RESPONSE TO PLANNING COMMENTS INCLUDING CALCULATIONS – Rev. D

SIMPLY UK

HOOK ROAD, PAGHAM

CS&P REF: 9418

ST1
(CLOSEST LOCATION TO TREES)
SCALE 1:20

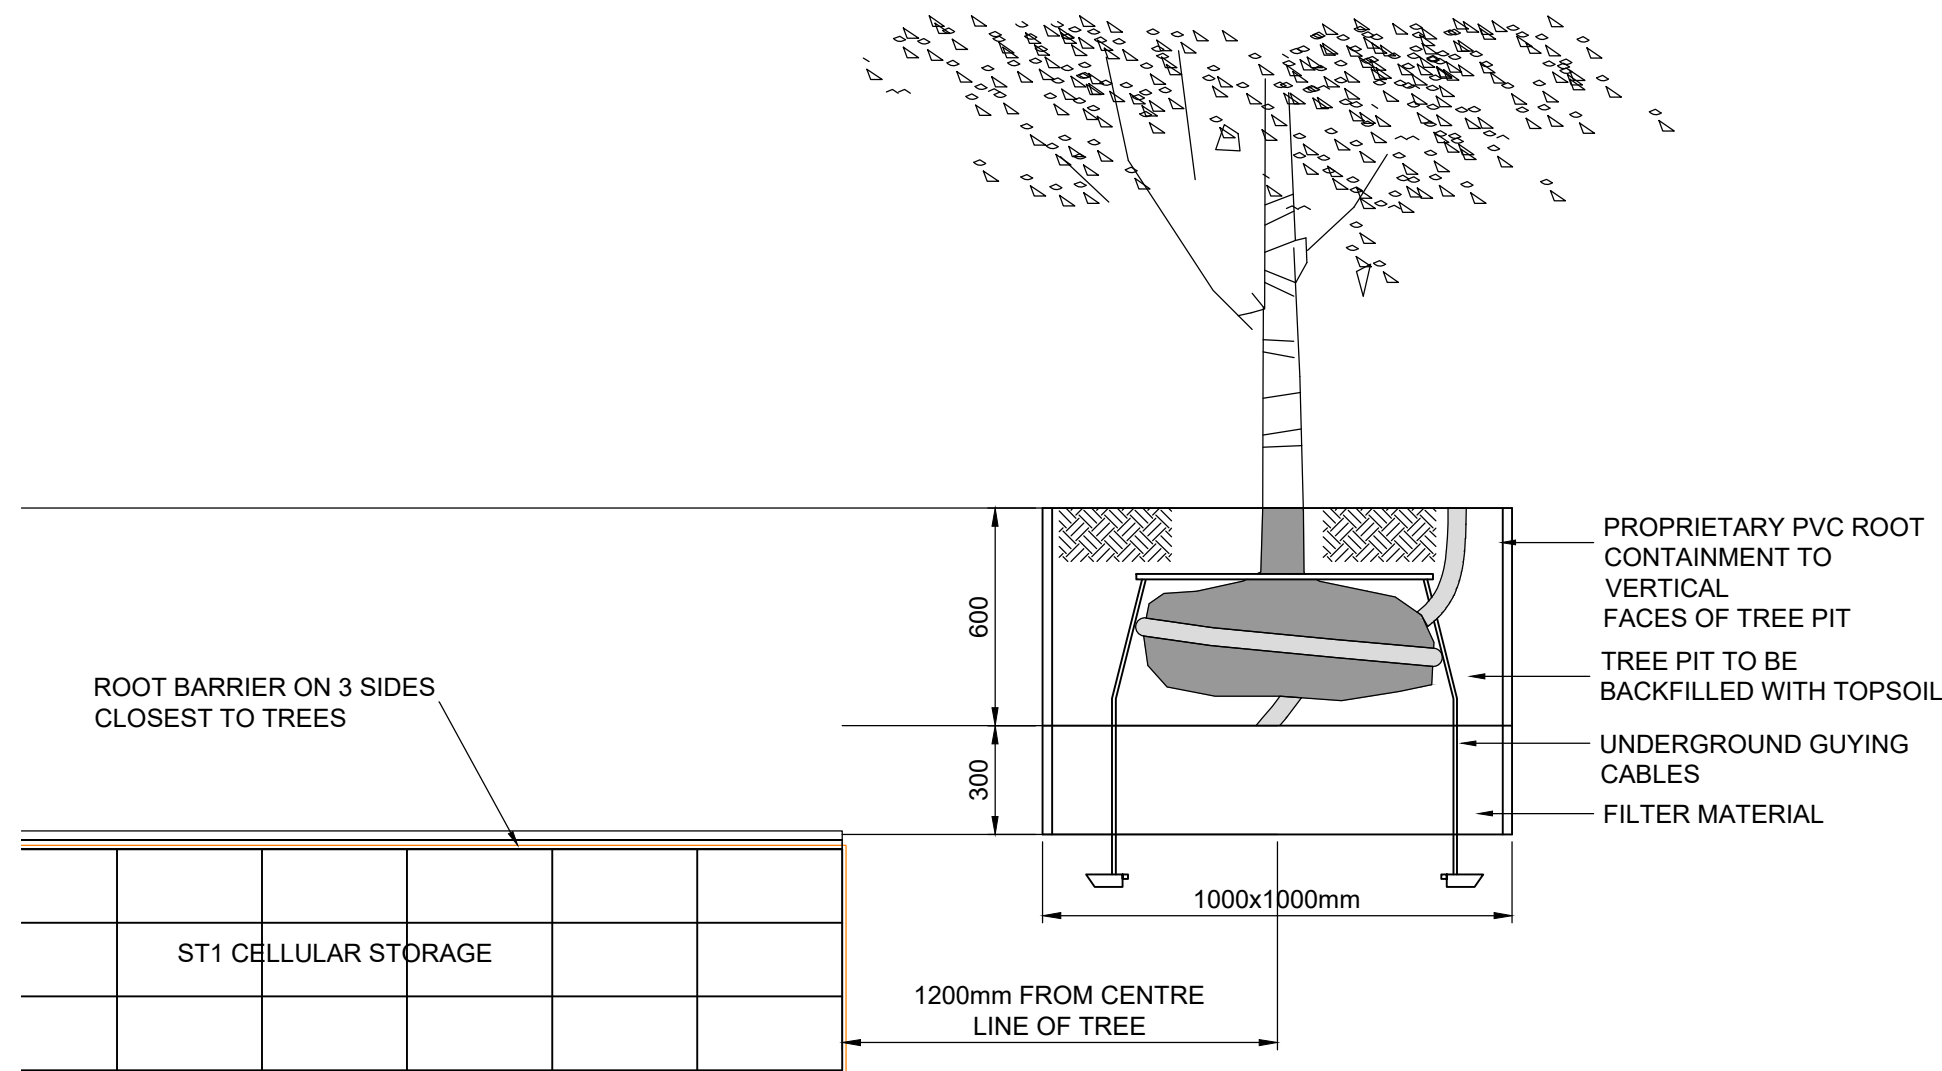
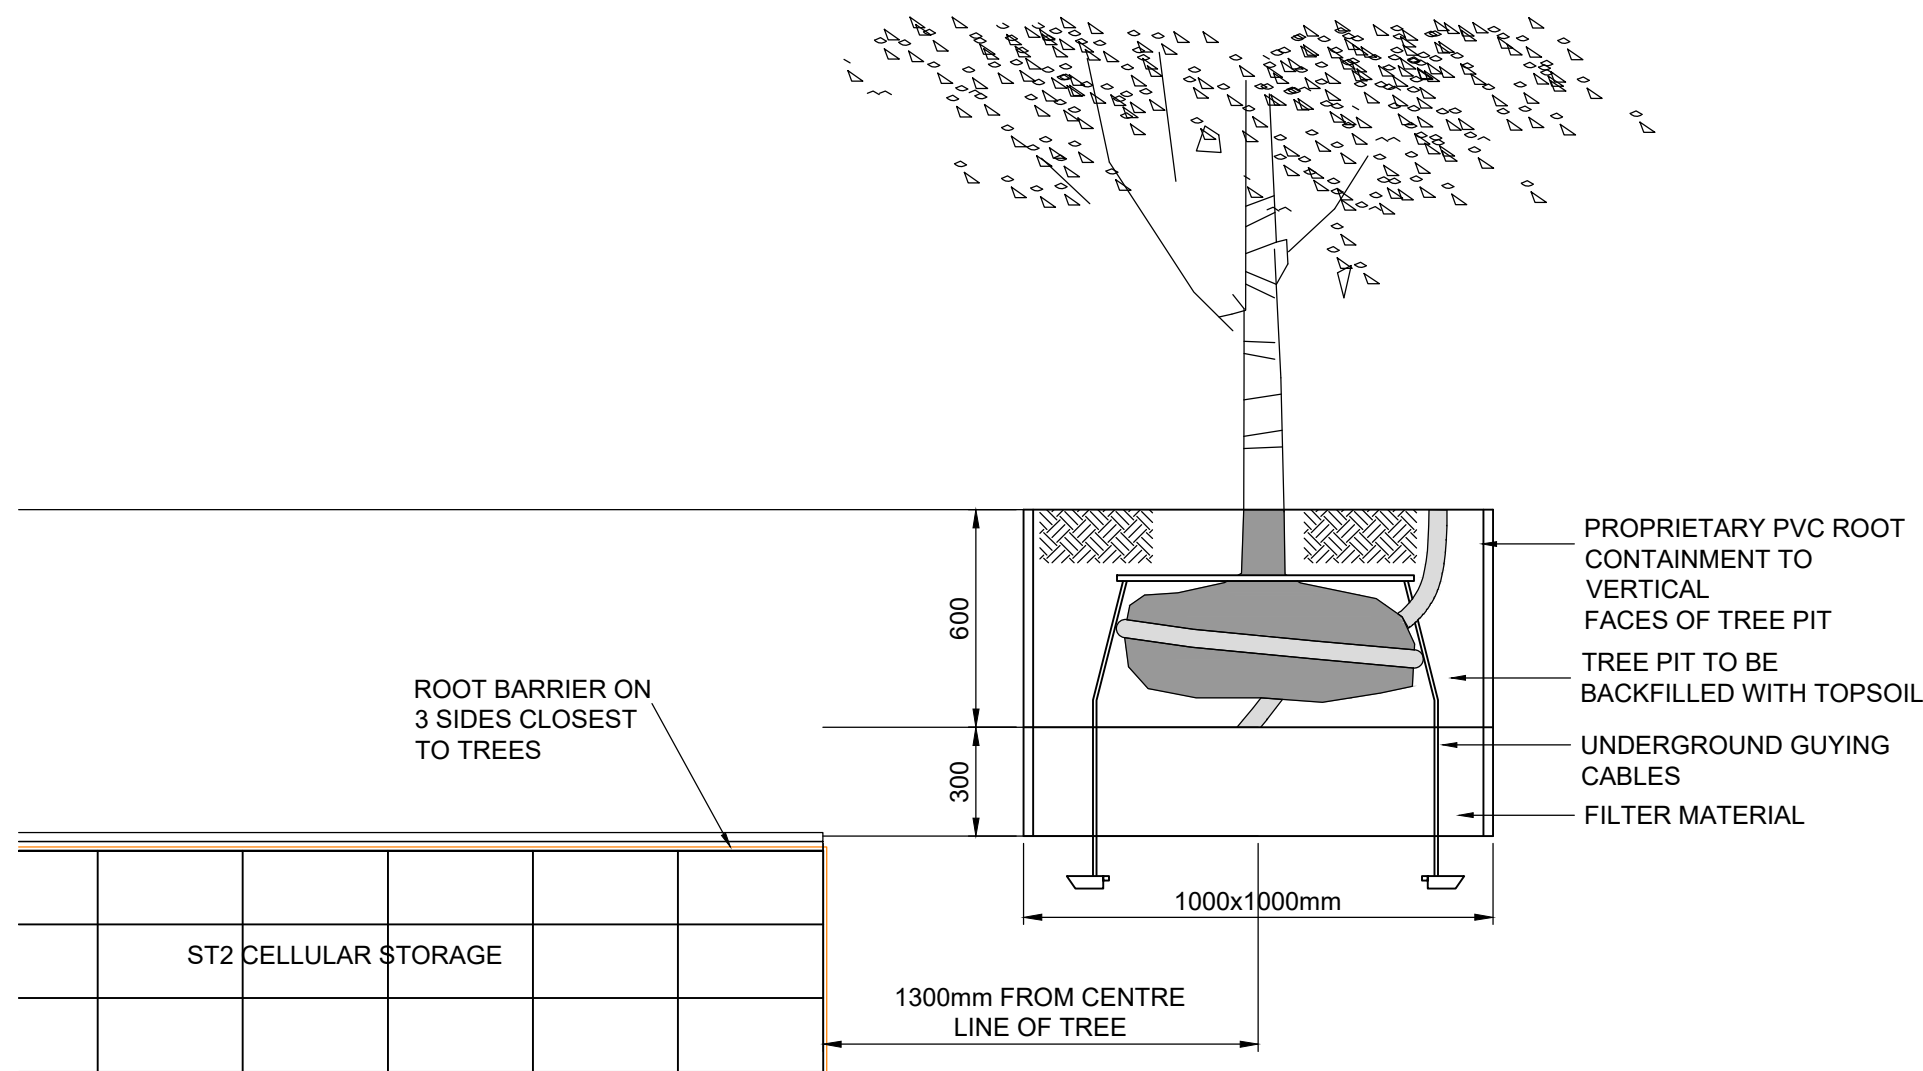
- a) The indicative landscape proposal drawing shows a tree very close to tank ST1. Section A-A provided does not appear to represent this.

- c) Demonstrate that the tanks are structurally sufficient given the close proximity of the trees.

We addressed in previous Revision C Calculations. We have updated our drawings in Appendix F. Section A-A is drawn to scale and indicates the distance/levels details of the closest tree next to the cellular Storage features.

See Appendix H for technical details relating to the structural details of the storage tanks.
